**RE: RIDBC CENTRE FOR EXCELLENCE (SSD 10451)
CULLODEN ROAD, MACQUARIE UNIVERSITY
RESPONSE TO SUBMISSIONS**

I write on behalf of RIDBC in relation to the current SSD DA for the new RIDBC Centre for Excellence at Culloden Road, Macquarie University and provide a response to submissions arising from the public exhibition of the project. I note agency submissions were received from the following:

In addition to a response to the submissions made and the Department's summary of key issues, WMK has also adjusted minor aspects of the development as a result of design refinement. These are submitted as part of this response for assessment and approval in the interest of avoiding a potential later need to seek modification of the consent.

Title
OVERALL PLAN - BASEMENT

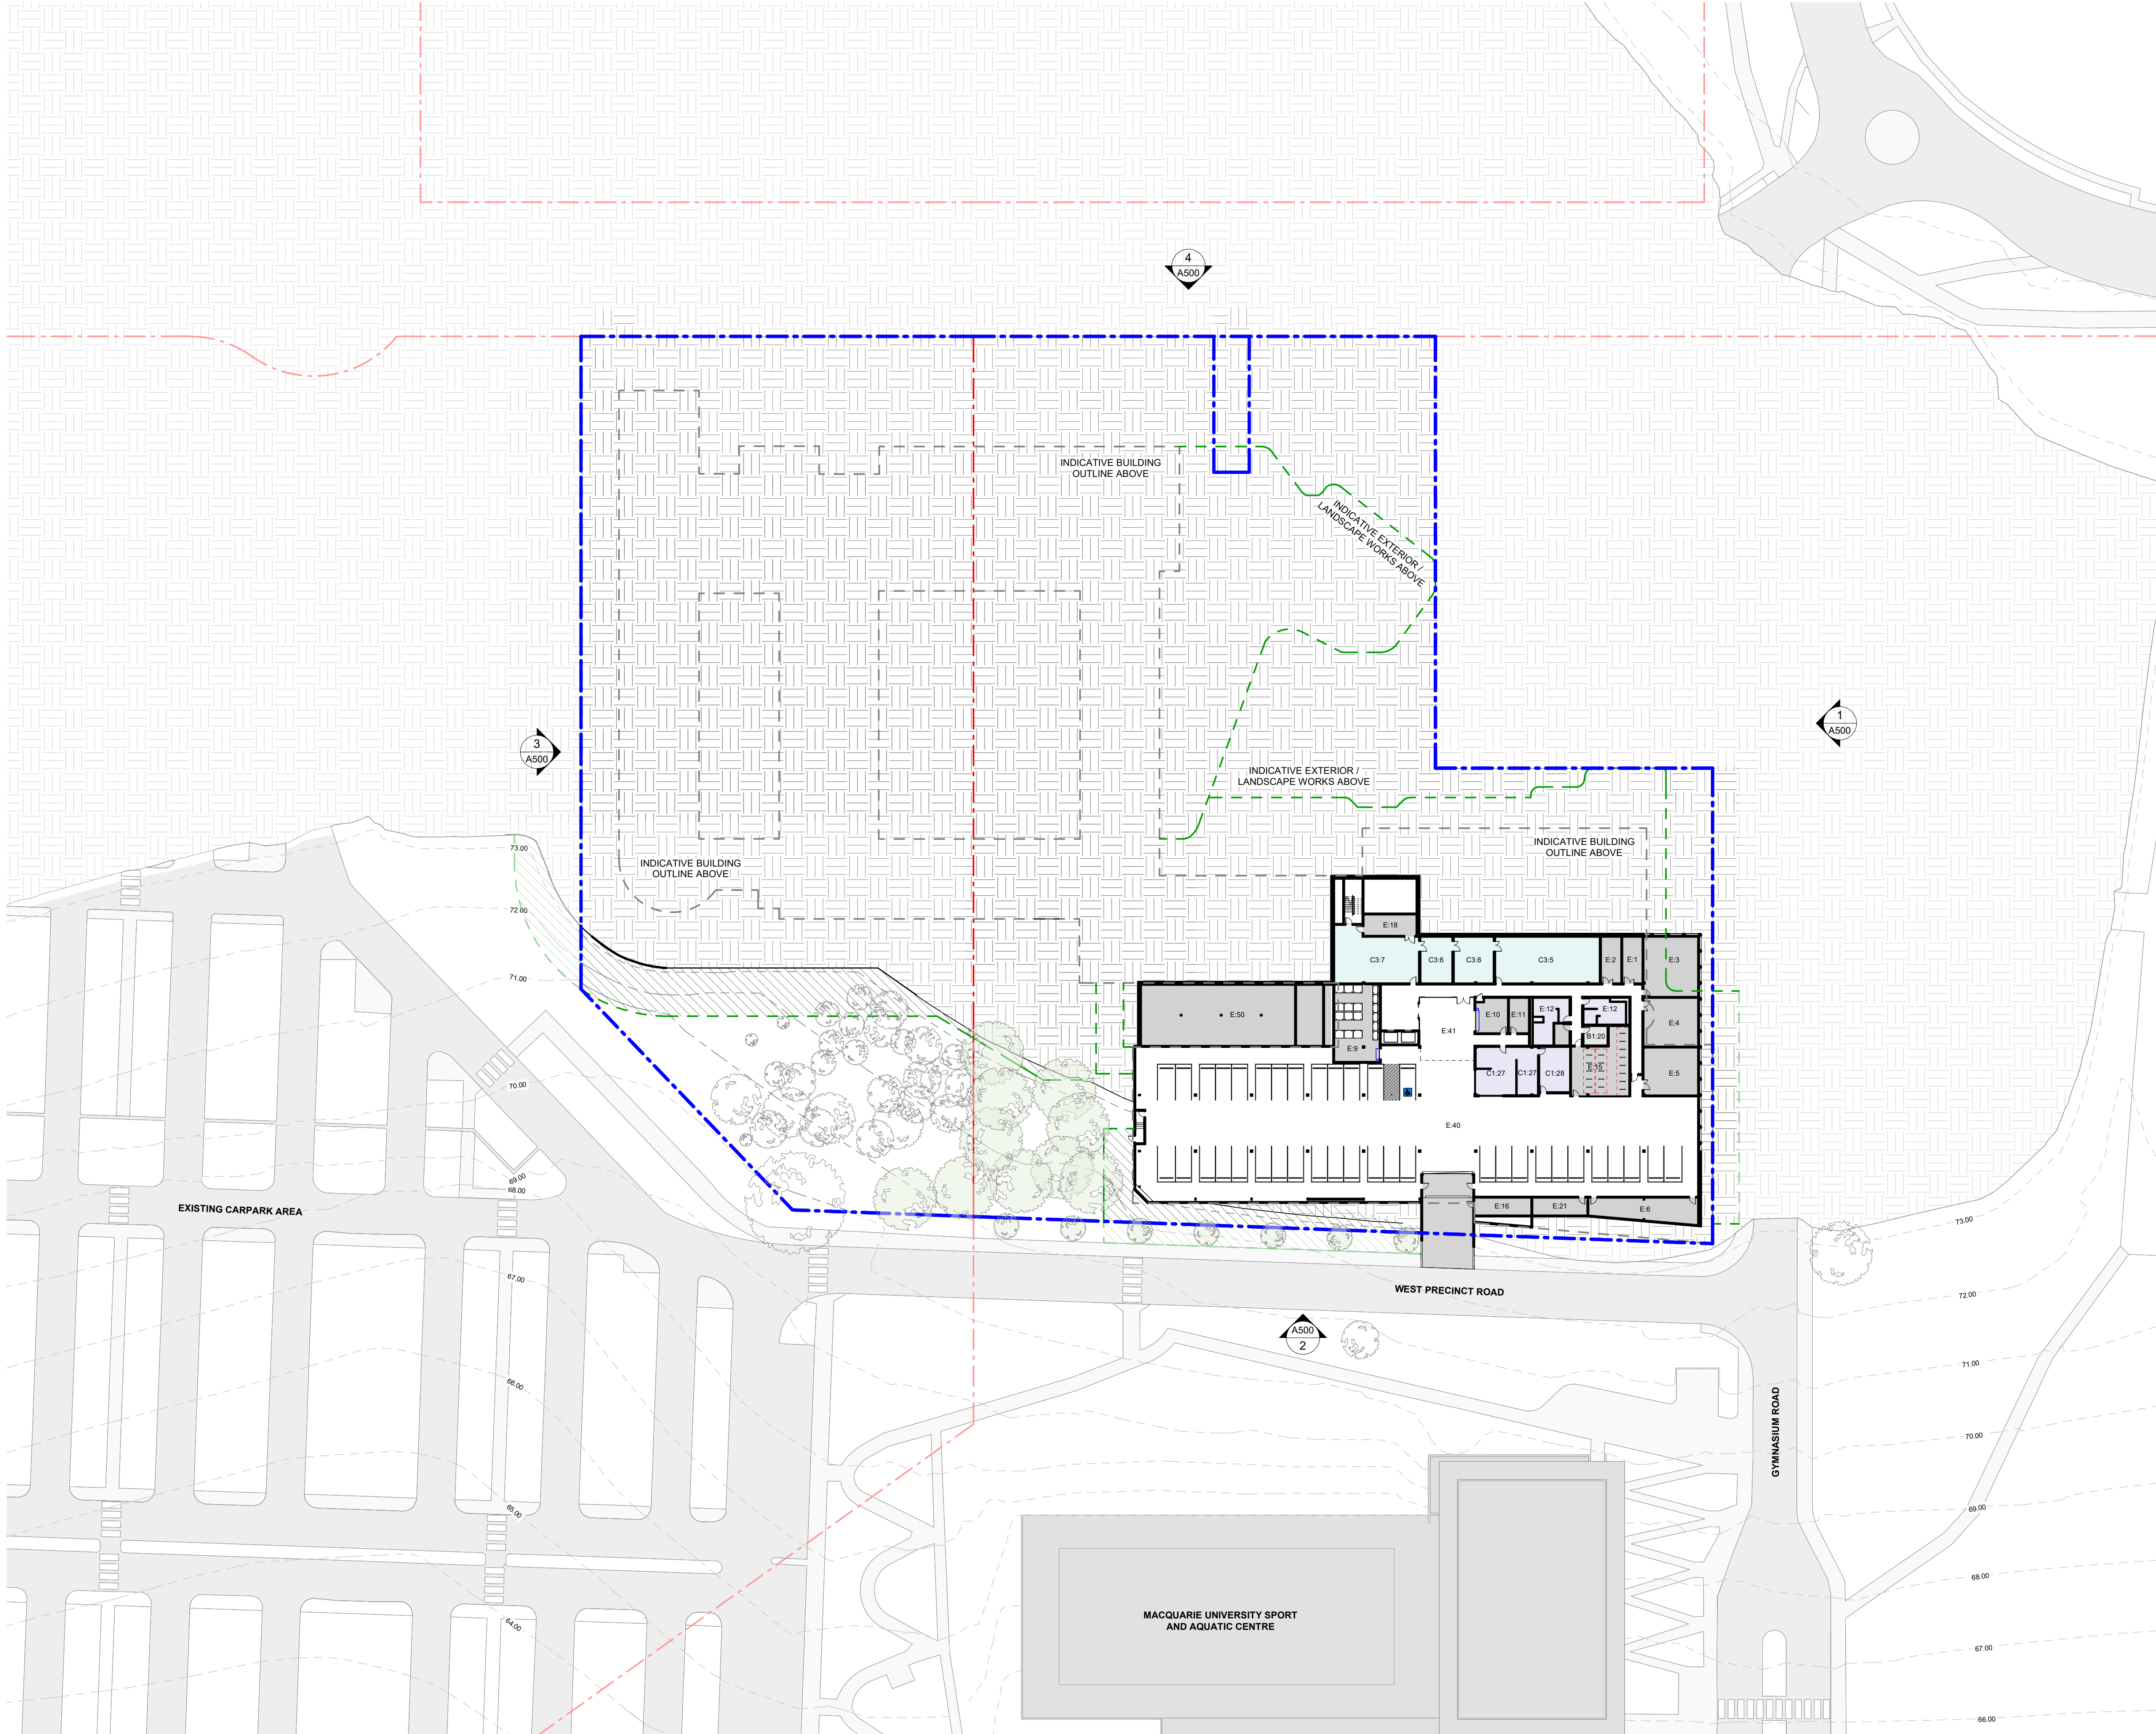
- The vehicular entry point off West Precinct Road and extent of the basement to the west has been adjusted.
- The workplace layouts have been reconfigured to best capture the RIDBC's current layout preference.

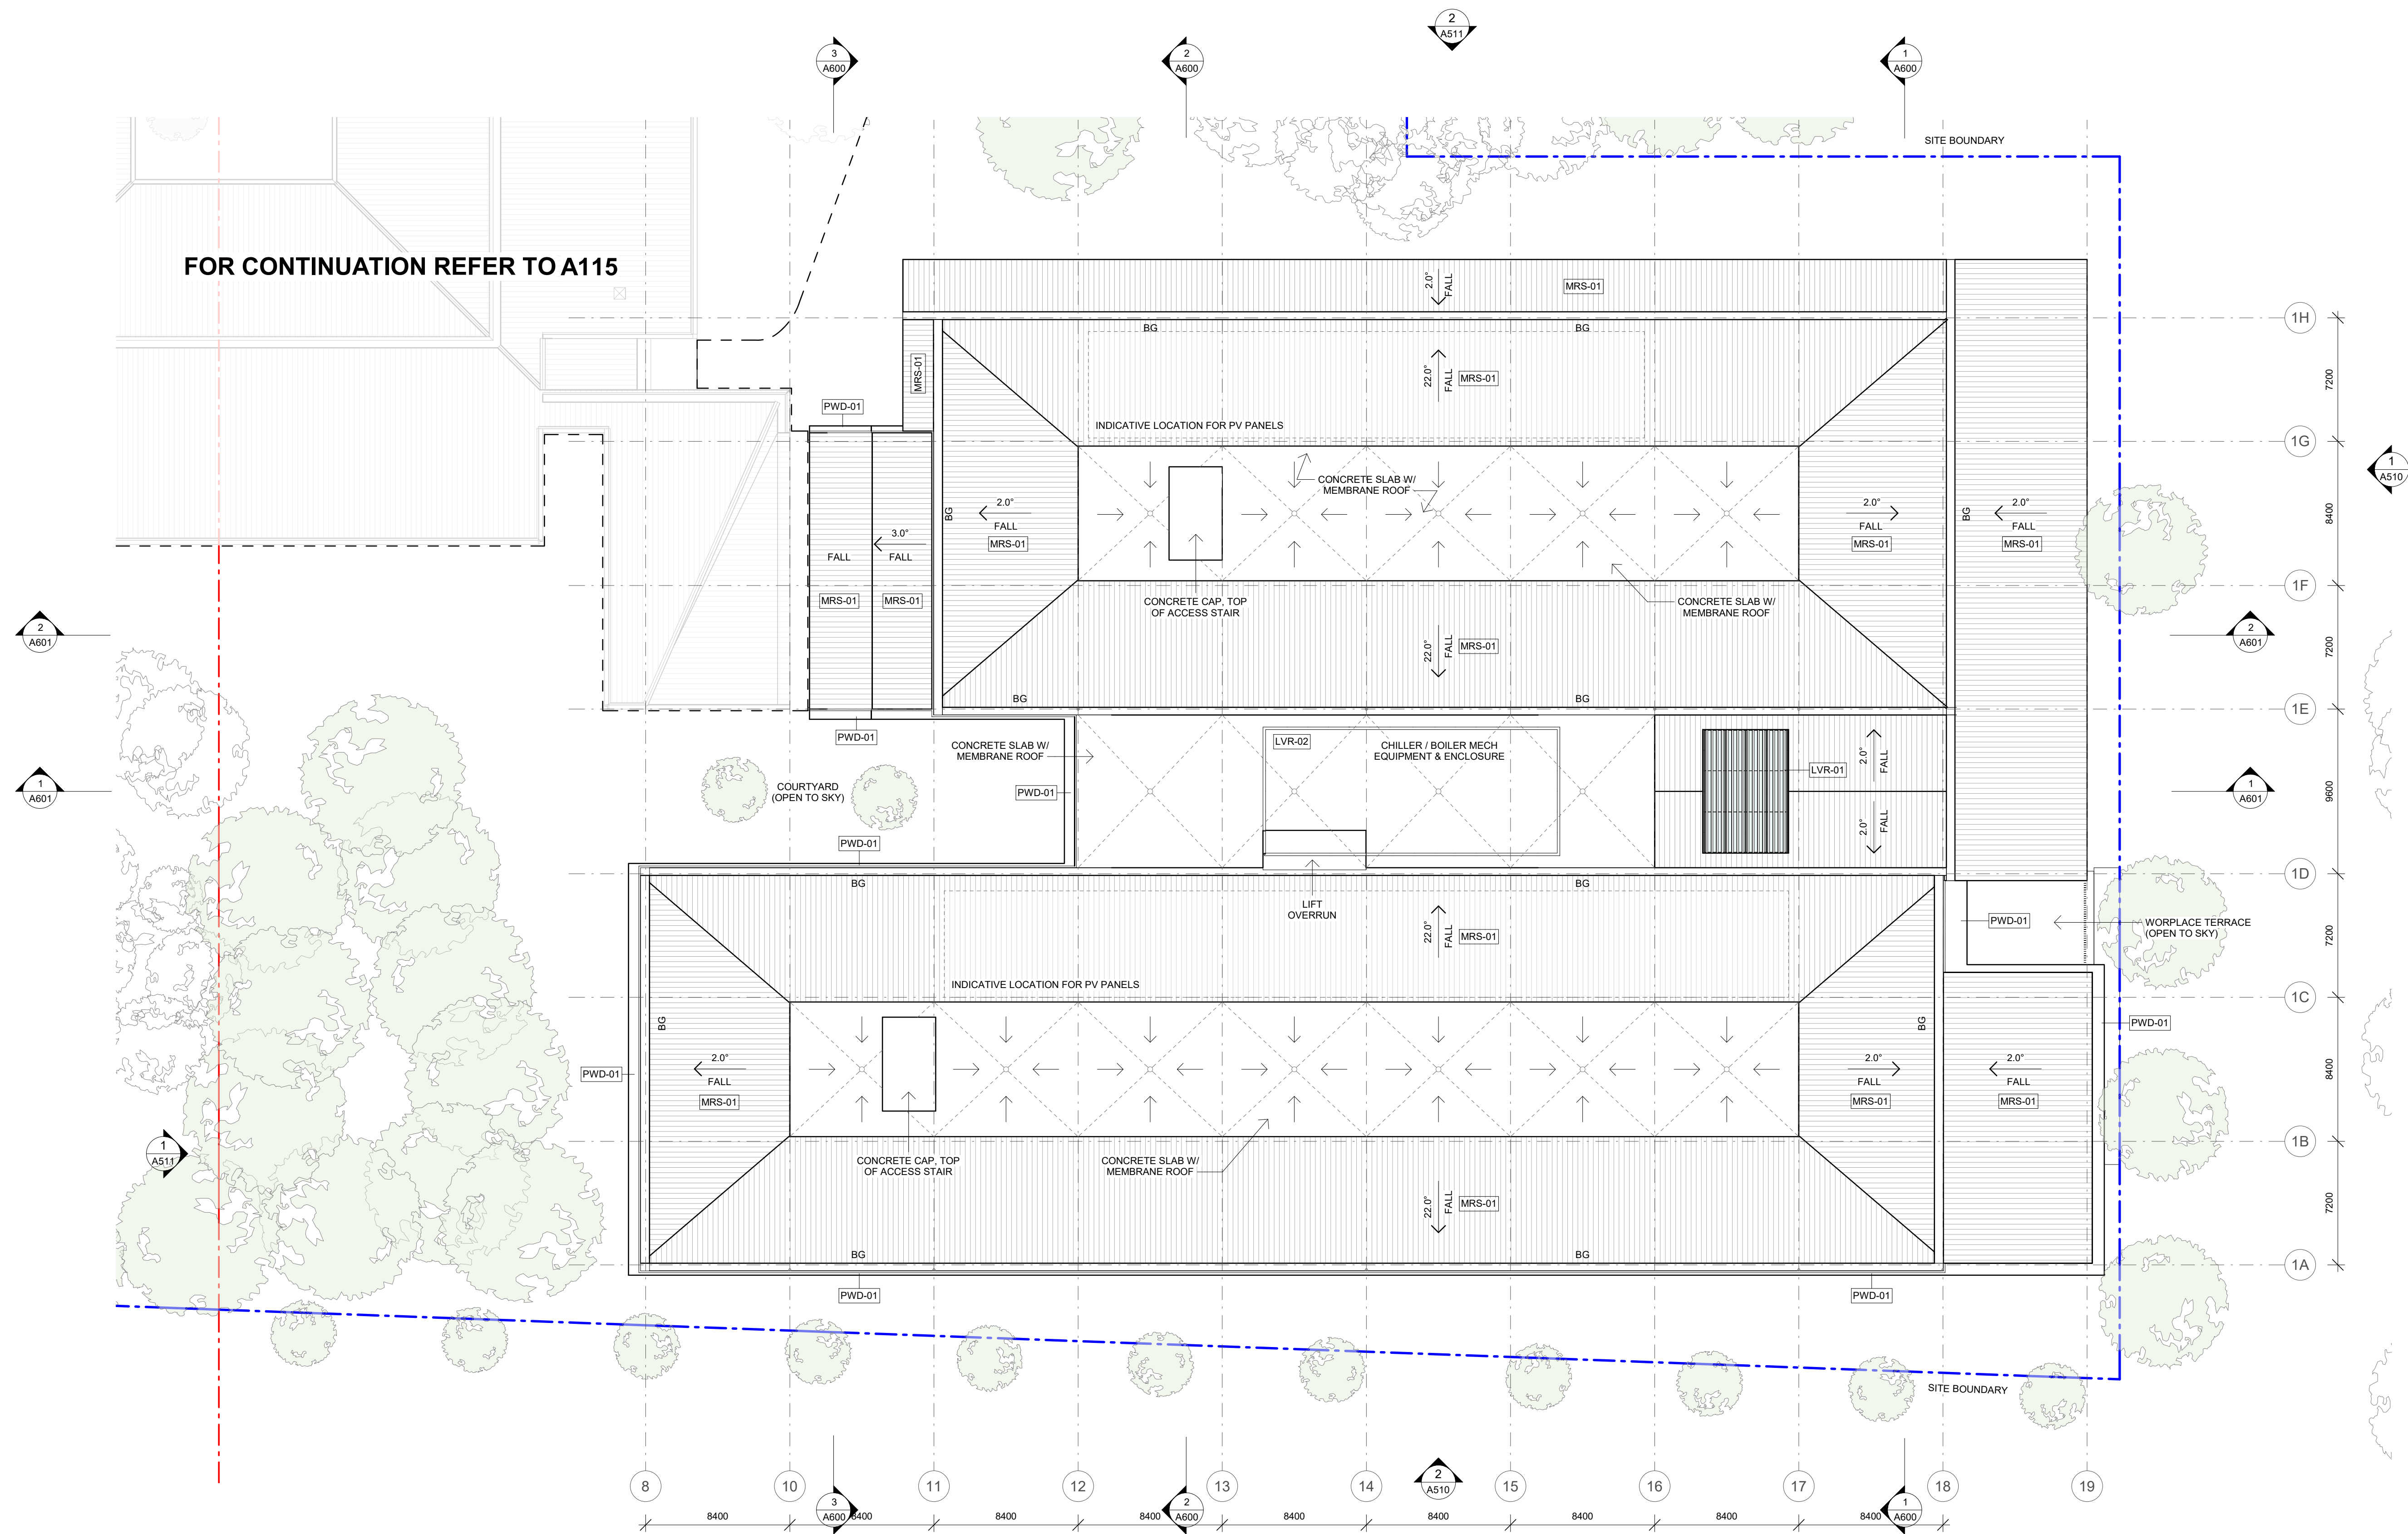
- The roof for the main building has been updated to maintain two plant areas with access hatches from below. These plant areas now drain onto the north and south skillions.

Pre-School Courtyard - Plan

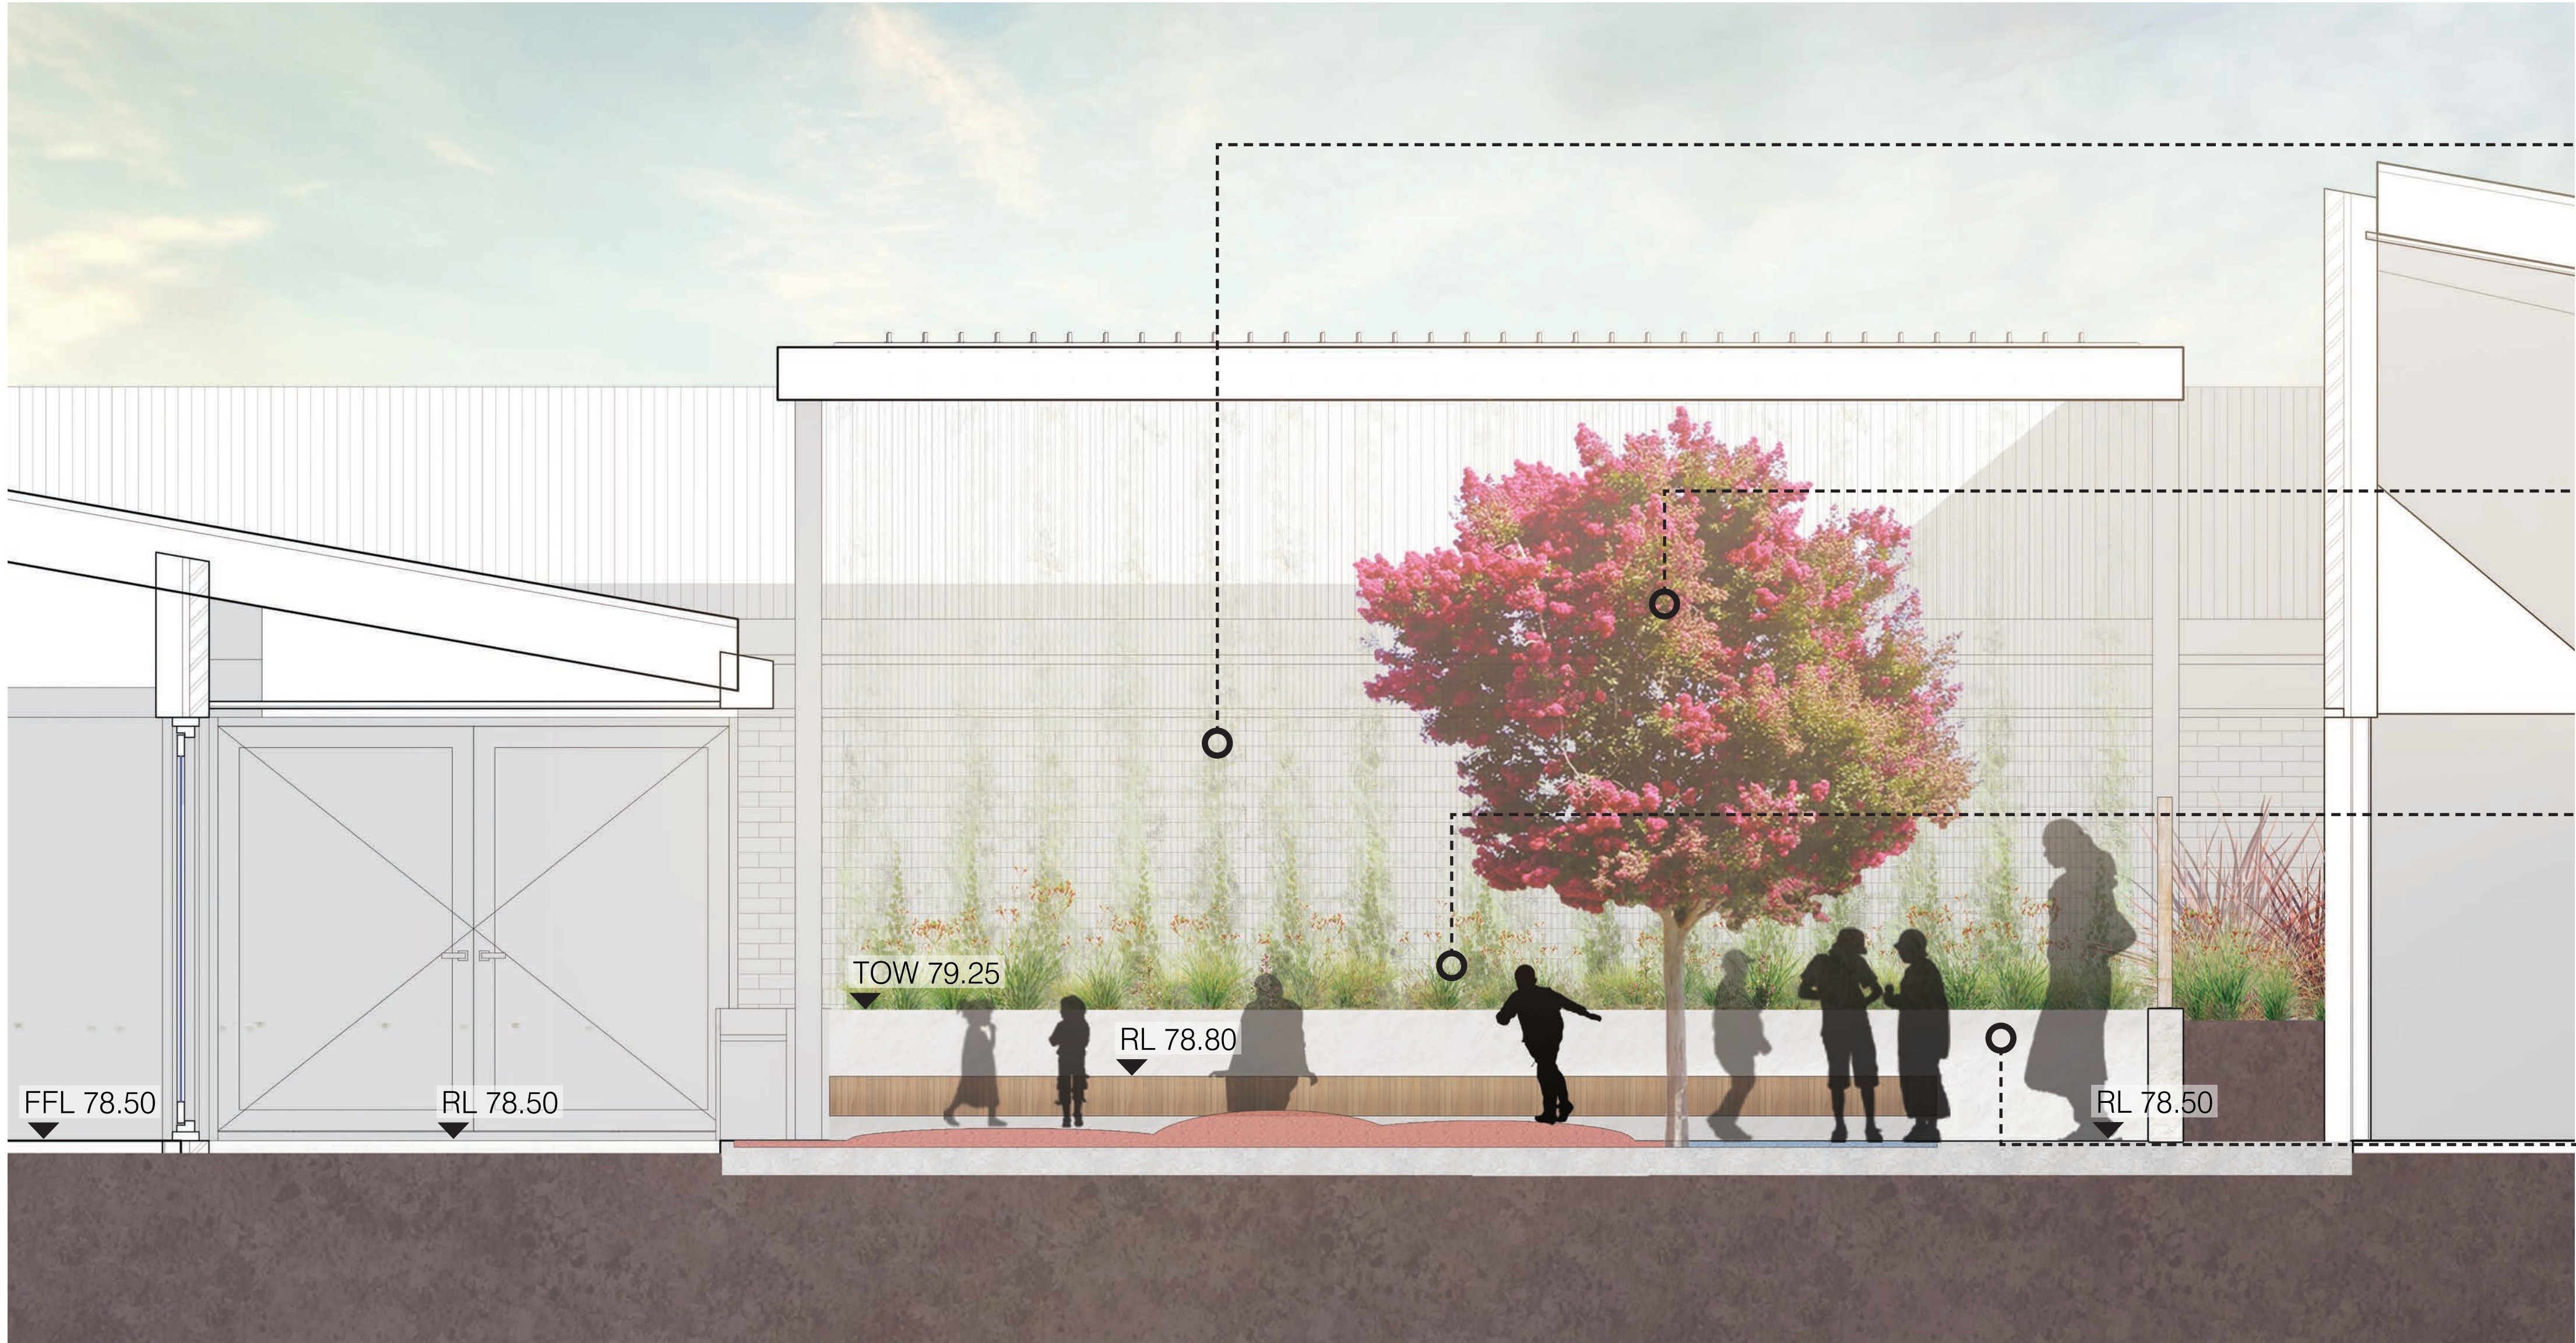
- The landscape shown in the architectural plans has been updated to better align with Oculus' current design – in particular for the primary school COLA area and the central courtyard of the main building. Note, the planter layout in the preschool courtyard has been adjusted to ensure the target outdoor learning area for students is met. Swales to the south of the site have also been shown.
